**From:** [REDACTED]  
**Sent:** 28 September 2023 12:57  
**To:** Planning  
**Subject:** planning application 3/2023/0424

For the attention of Kathryn Hughes  
26 Sept 23

PROPOSED SITE PLAN. SCALE 1:200

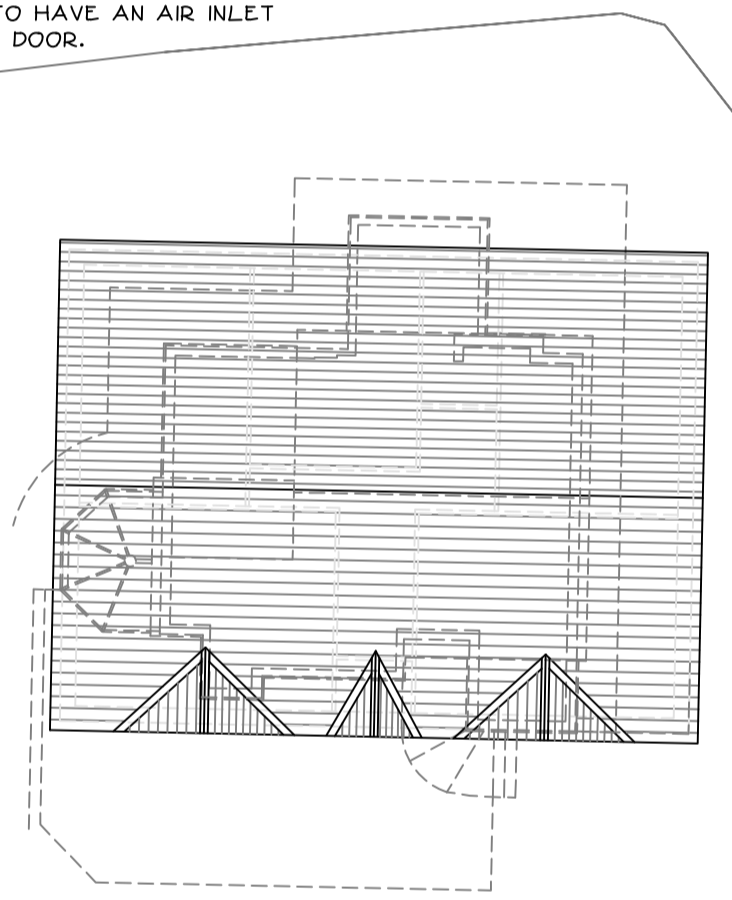
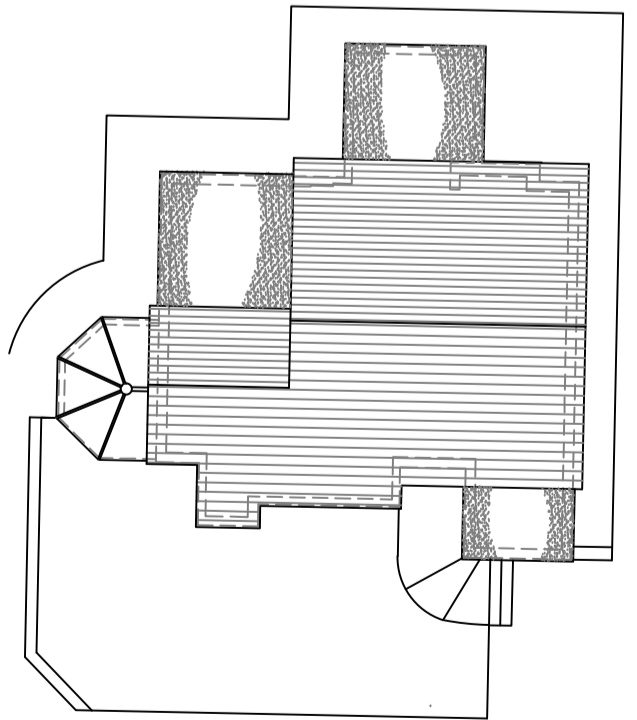
- 6 The plans appear to show that land associated with Sunnyside include a parcel adjacent to it. This was not included in the auction and was always separate to it. The previous owner did discuss this when I visited whilst she still lived there.
